Appendix A – Response to DPHI RFI

Table 1 Response to matters raised by Department of Planning, Housing and Infrastructure (DPHI)

Drawing Name
SITE PLAN & ANALYSIS

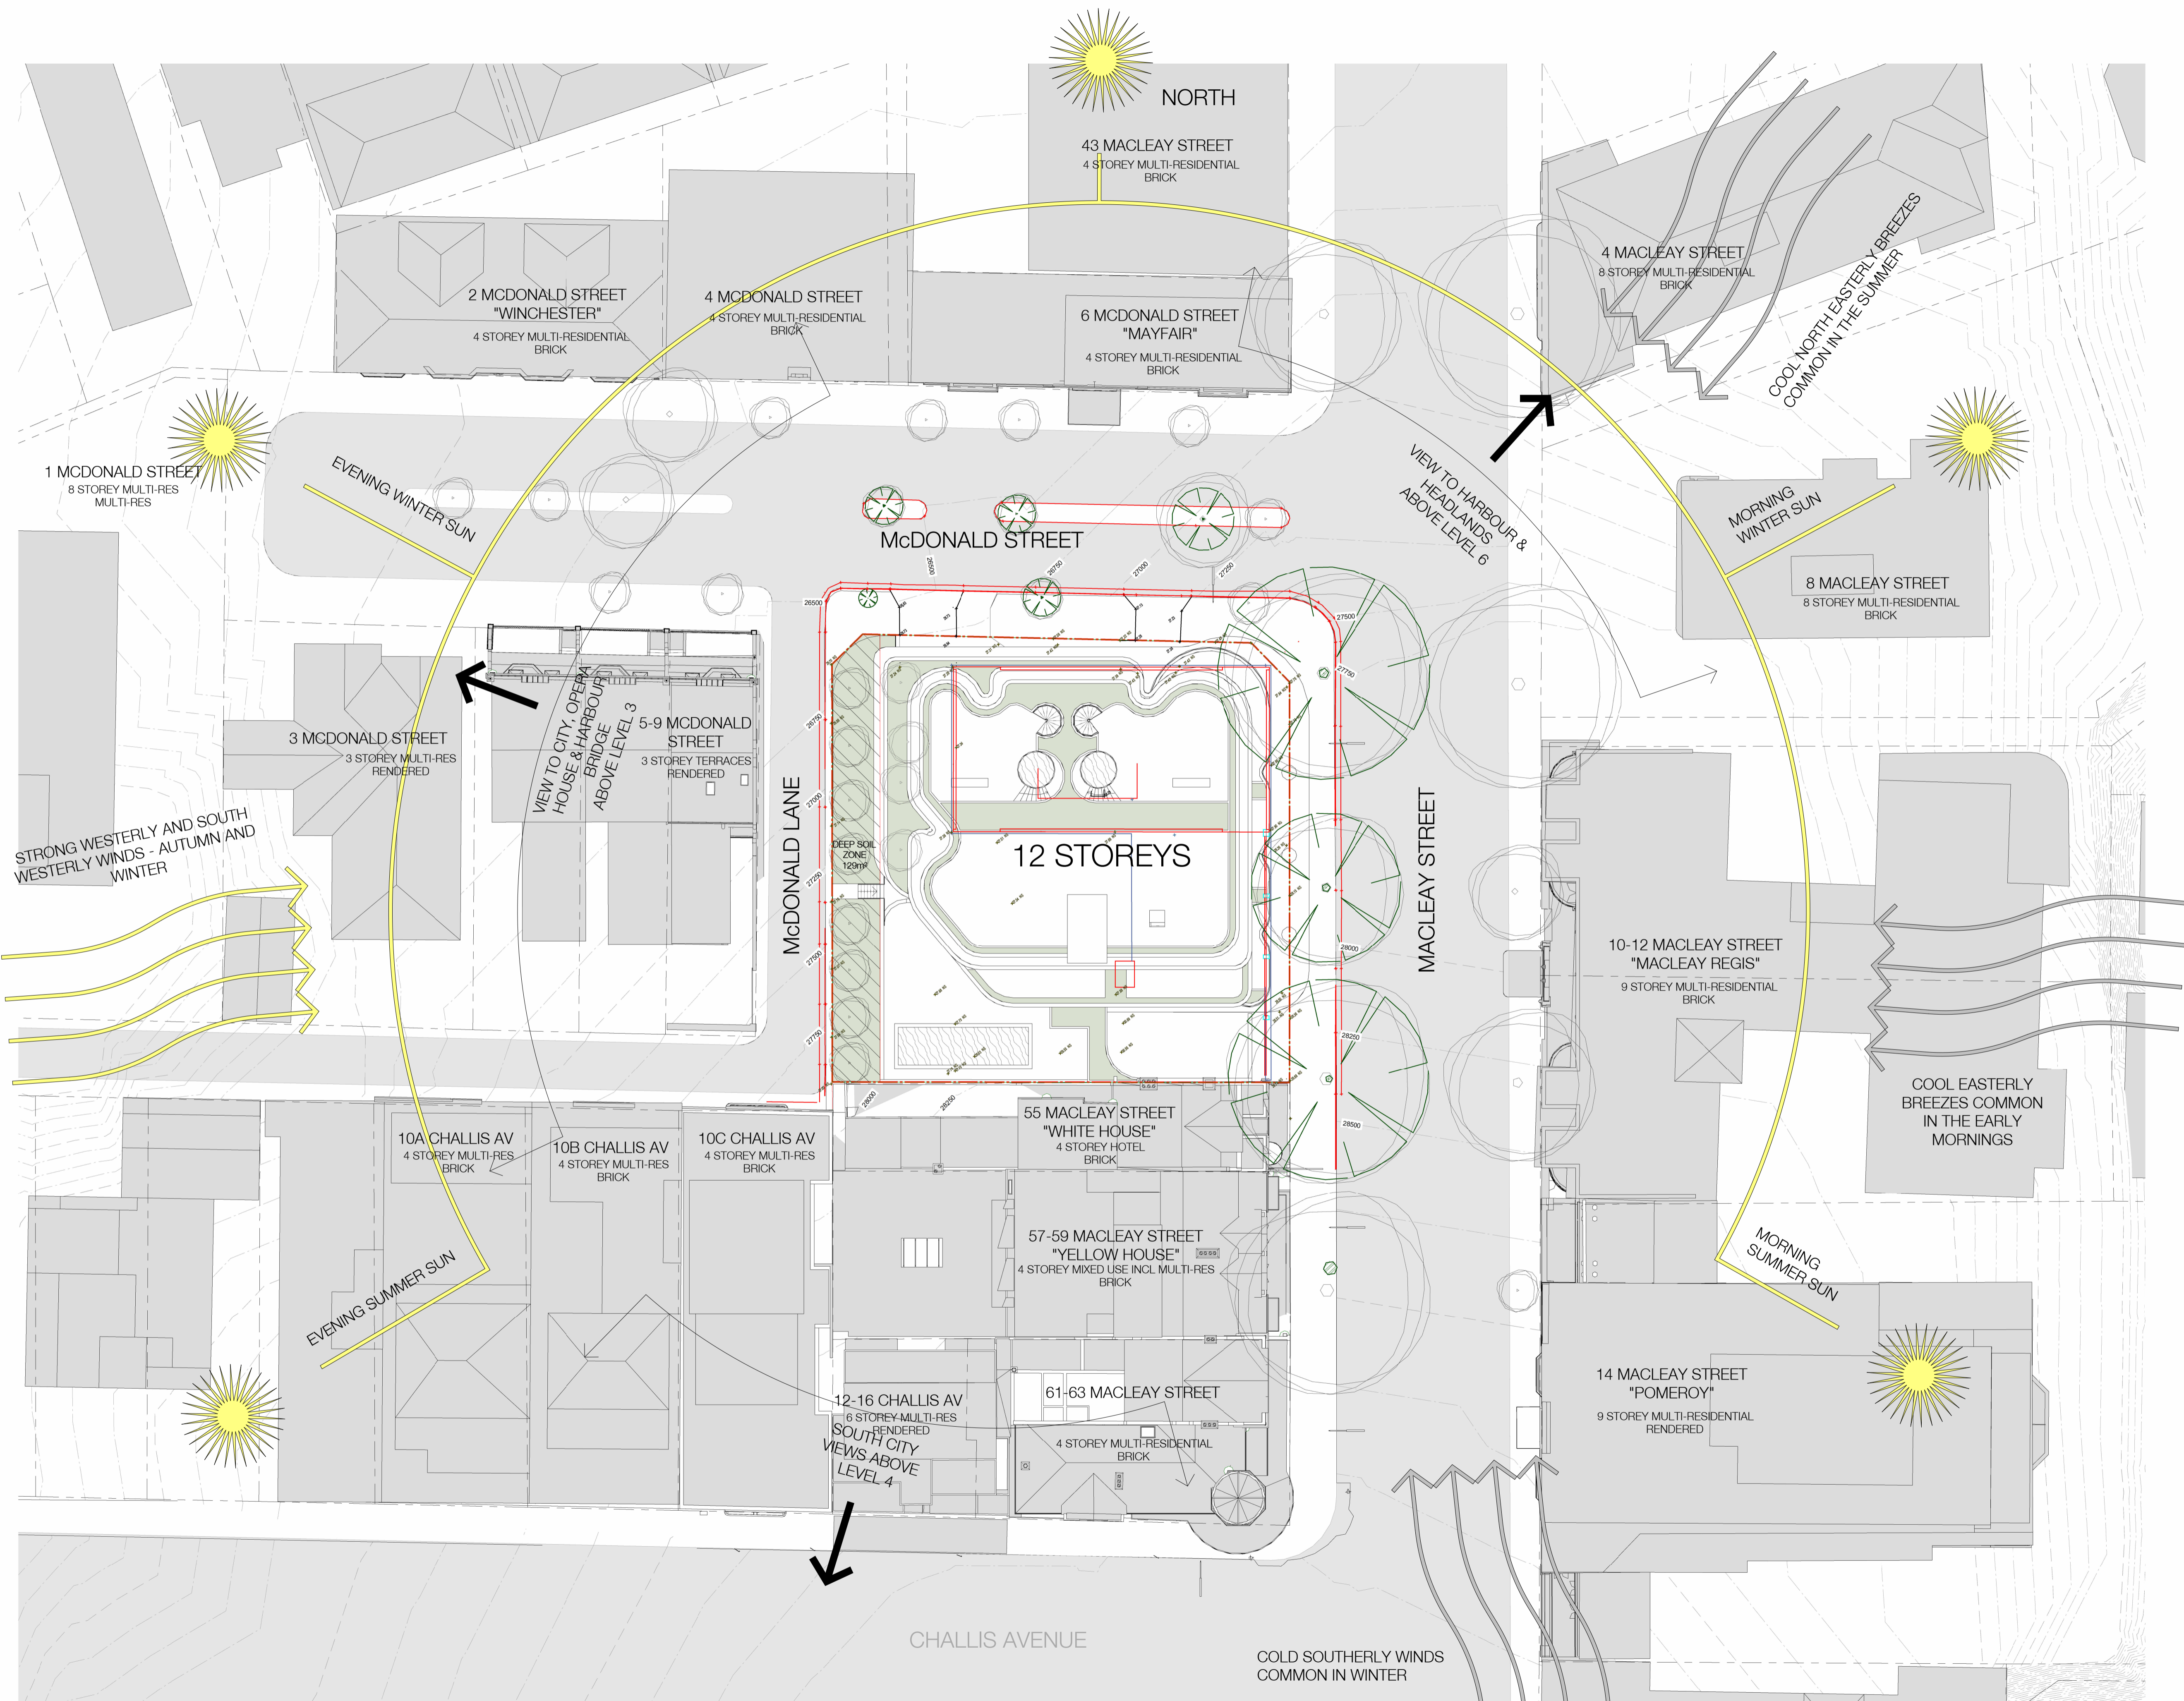
(b) Indicate the location and area of deep soil zones on the site plan.	The deep soil zone is proposed to be located along McDonald Lane and has been depicted in the updated Site Plan at Appendix B.	Appendix B
(c) Align the basement setbacks between the site plans and elevations. Specifically, the 2m eastern setback and the 3.8m western setback to the basement depicted on the site plan are not accurately depicted on the elevations.	The envelope elevation plans have been updated to show the basement setbacks at Appendix B.	Appendix B
(d) Detail the street names/frontages on the height plan diagrams.	Amended height plane diagrams containing street names have been provided at Appendix B.	Appendix B
